**RESPONSE TO REQUEST FOR ADDITIONAL INFORMATION
SSD 7388 MOD 14 – 31 WHEAT ROAD, SYDNEY (THE RIBBON)**

This letter has been prepared by Ethos Urban on behalf of Tianlong Ribbon Pty Ltd (Greateon), in response to the Requests for Additional Information (RFIs) for SSD 7388 MOD 14 issued by the Department of Planning, Industry and Environment (DPIE) dated 5 November 2021. It also responds to additional items raised in email correspondence by Jennie Yuan (Planning Officer, Key Sites Assessments) dated 22 November 2021.

GFA AREA SCHEDULE

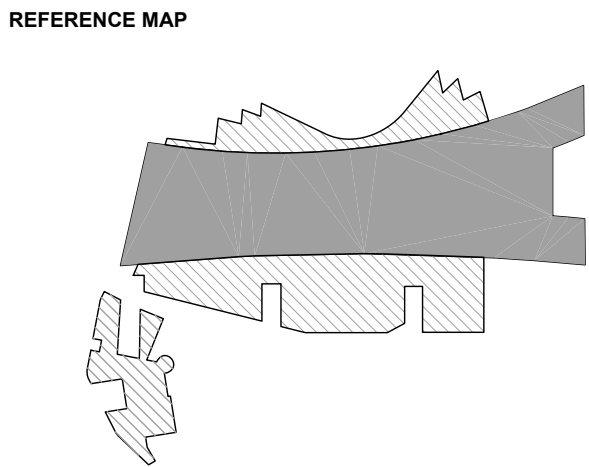
Response to email correspondence – 22.11.2021	
<p><i>Please check and confirm the proposed total GFA and the GFA of each level (the numbers/levels between Attachment A Page 1 and Attachment B Page 5 seem not matching)</i></p>	<p>The GFA Plans submitted at Appendix B of the MOD 14 package were only for information purposes. The Updated Architectural Plans at Attachment A provide the final confirmed GFA figures for the building.</p>
<p><i>Please confirm the proposed increase of GFA (my calculation is 968 m2 if we use the total GFA numbers in MOD 10 and Attachment A Page 1 while the report states 986 m2)</i></p>	<p>968m² is the correct figure. There was a drafting error in the originally submitted report.</p>
<p><i>Please confirm the design of the space in the south of the lift lobby (the layouts look different between Attachment A Page 6 and Attachment B Page 7 & 9) and whether it is going to be used for serviced apartments.</i></p>	<p>The confirmed layout of the space is shown in the Updated Architectural Plans at Attachment A. The layout is approved and does not form part of the MOD 14 scope.</p>

DRAWING TITLE
LOWER SITE PLAN

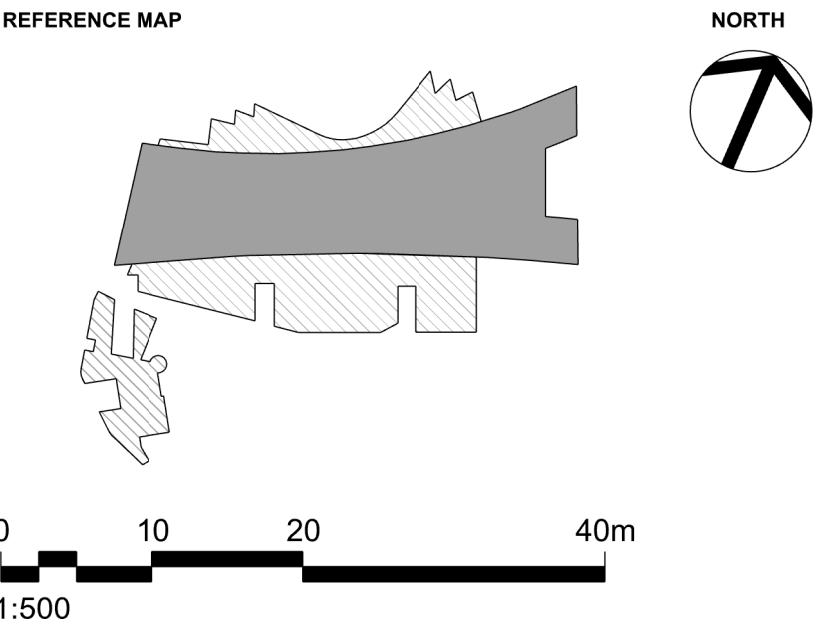
Item raised	Proponent's response
Response to DPIE RFI – 5.11.2021	
<p><i>Revised site plan and ground floor plans:</i></p> <ul style="list-style-type: none"> correctly reflecting the approved layout of SHFA Building in MOD 13 and the approved public domain design in MOD 11 labelling the proposed stormwater filter room. 	<p>Refer to Updated Architectural Plans prepared by Hassell (Attachment A). The Plans have been revised to correct the previous inconsistencies with MOD 13 and to label the stormwater filter room.</p> <p>Final public domain design does not form part of the current project scope and will be submitted at a later date to DPIE for approval in accordance with condition B4 of the SSD 7388 conditions of consent.</p>
<p><i>Further details of the 'new access points for existing electrical vault' at the southern side of the Ribbon, and any CPTED measures required.</i></p>	<p>The electrical vault (Vault O) itself remains unchanged. MOD 14 only seeks to provide a new staircase for authorised personnel to access and transport materials/machinery to the vault from the western side of the building in response to an Ausgrid requirement.</p> <p>This new access staircase will not be open to members of the public. It is shown as being within the 'Secure Area' on the Architectural Plans, being fenced off and swipe card access will be required for entry. Therefore, the introduction of the staircase does not materially impact CPTED.</p>

GA PLANS - GROUND FLOOR

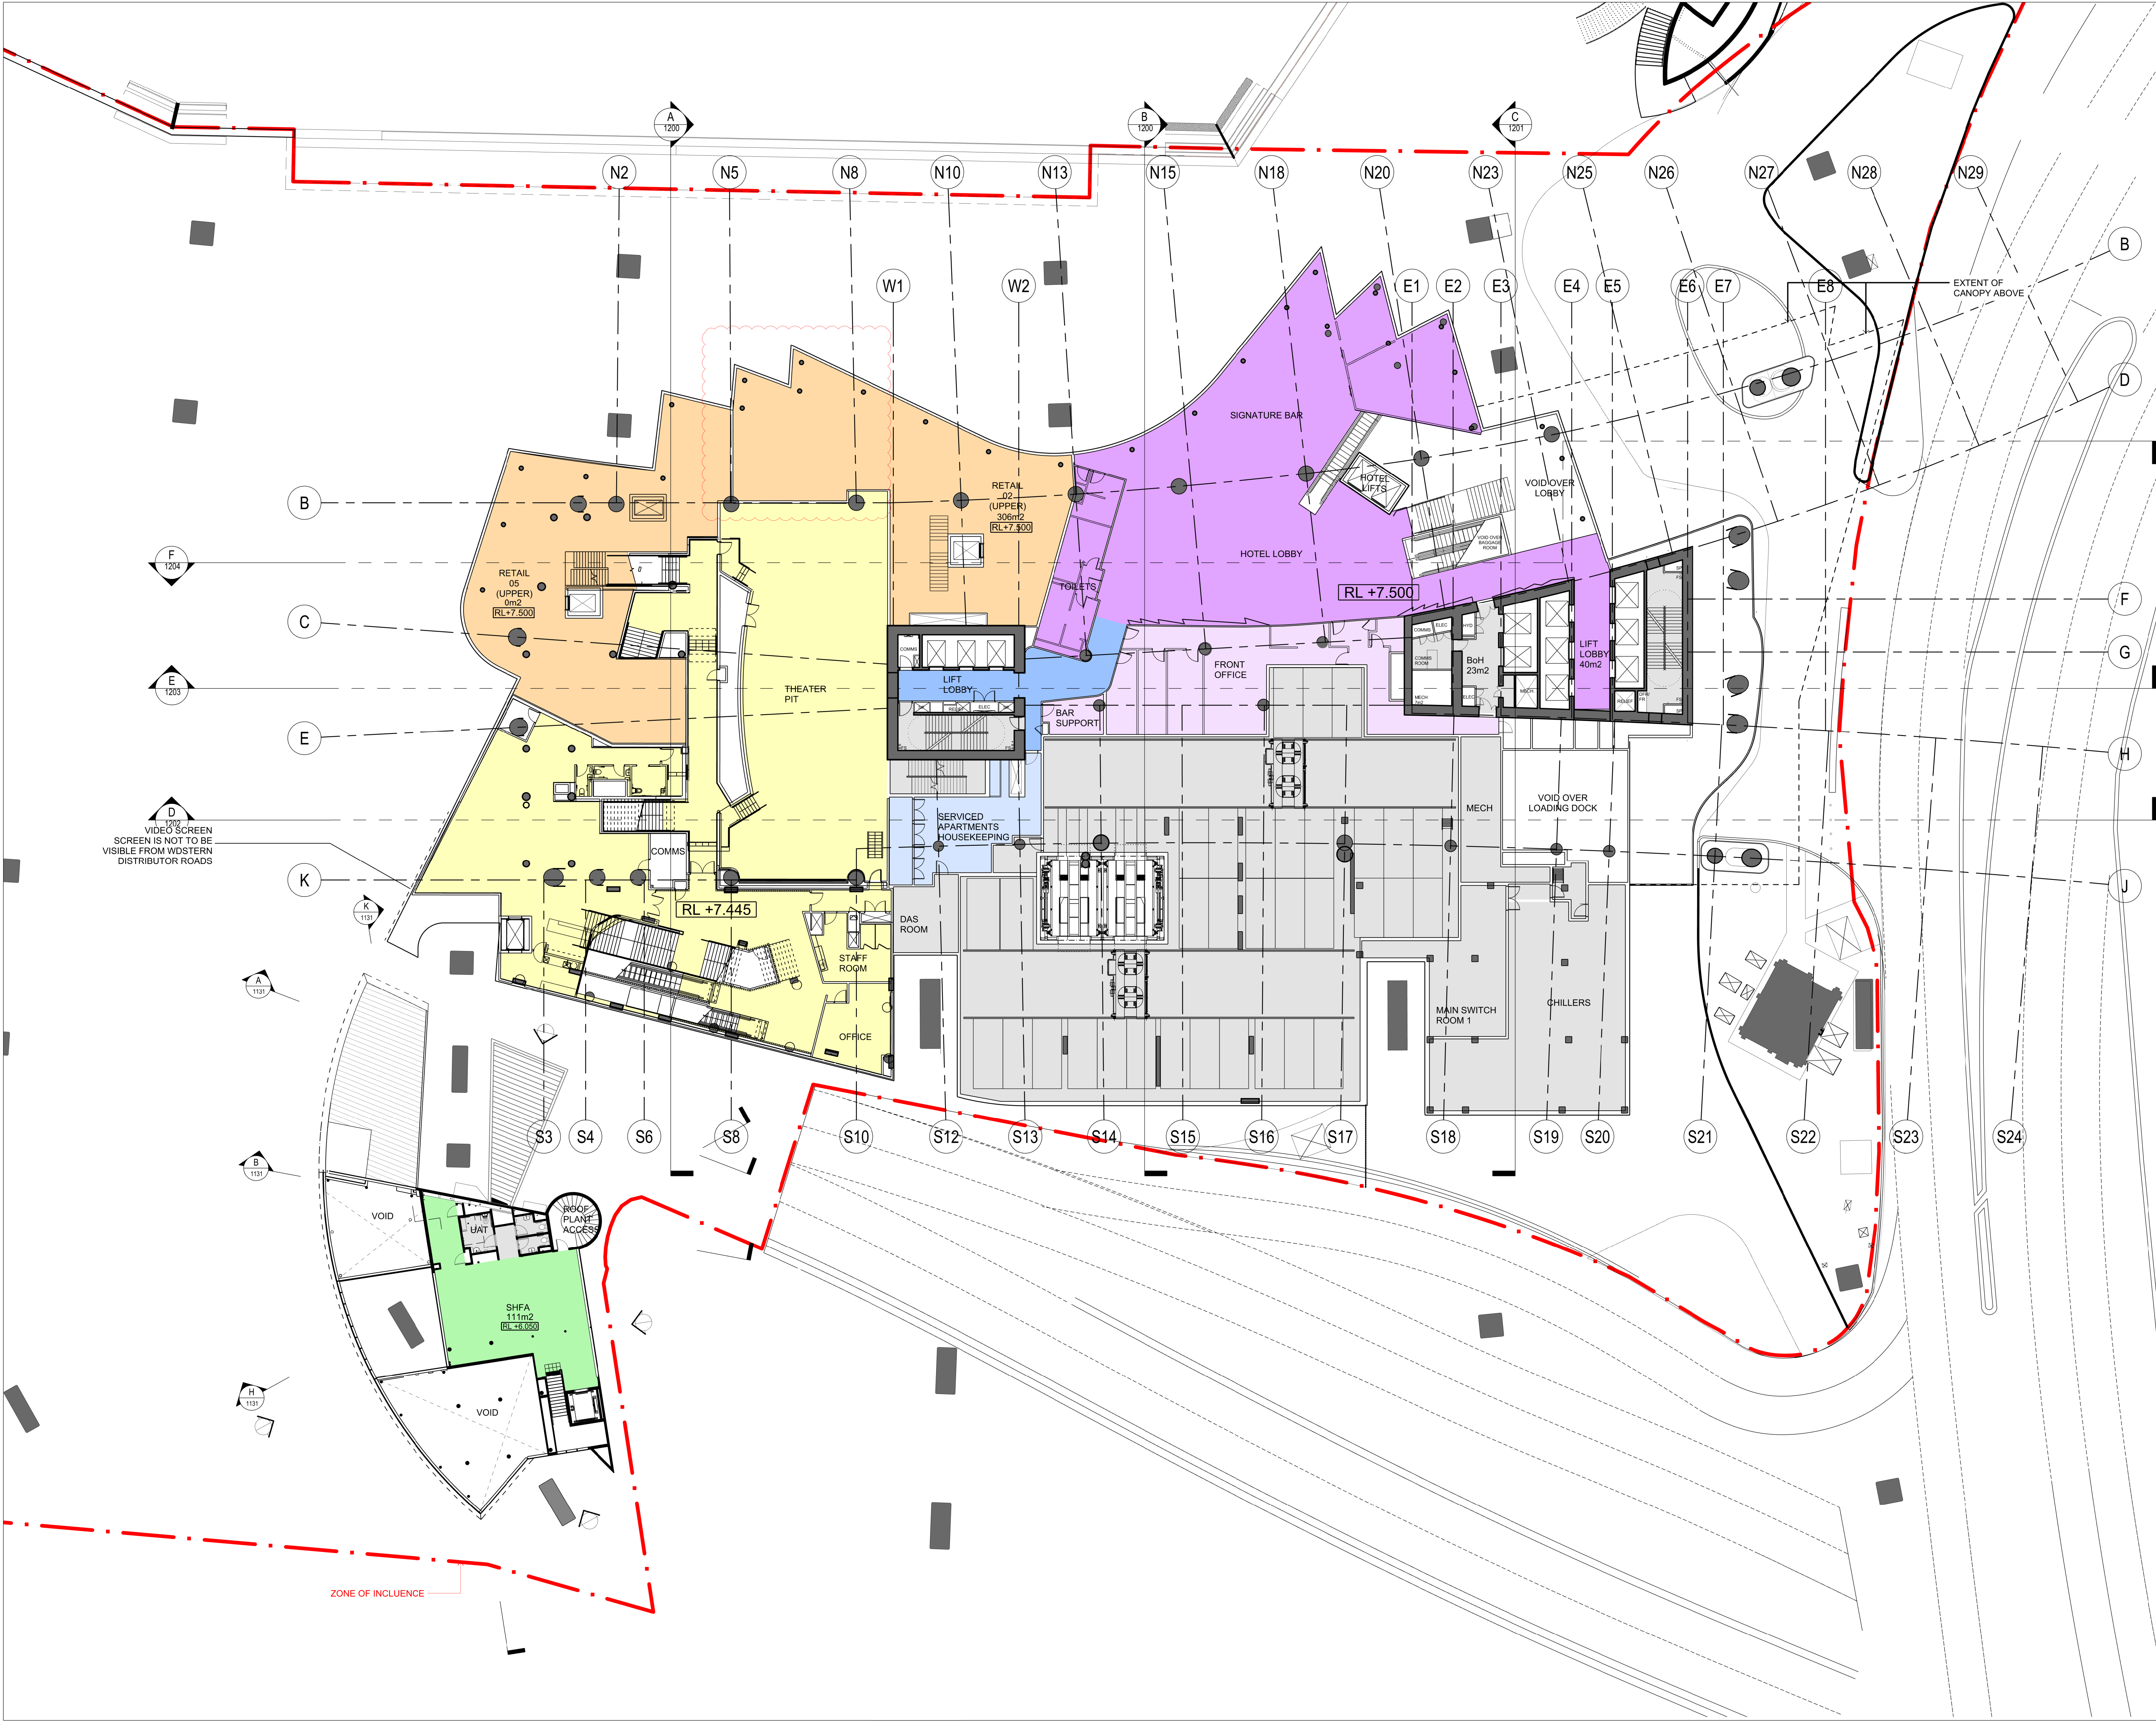
<p><i>Confirmation if the doors of Retail Tenancies 2-6 are proposed to be changed to operational glazing as indicated on the site plan.</i></p>	<p>The doors of Retail Tenancies 2-6 are proposed to be changed to operational glazing. This change is now clouded in the Updated Architectural Plans at Attachment A.</p> <p>The change will align their appearance with that of the SHFA Building tenancies under MOD 13 and improve streetscape activation as well as the tenancies' integration with the surrounding public domain.</p>
<p><i>Confirmation if Retail Tenancy 5 has stairs/fire-safe exit to get down from Level 1 to the ground floor. Based on the proposed Podium Level 1 Plan, Retail 05 (upper) only has a lift, which is not consistent with what is indicated on the ground floor plan and in the Attachment C - Fire Statement.</i></p>	<p>It has always been the intention for stairs/a fire-safe exit to be provided for Retail 05 from the first to ground floor. There was a minor drafting error in the originally submitted Plans which has now been rectified in the Updated Architectural Plans at Attachment A.</p>
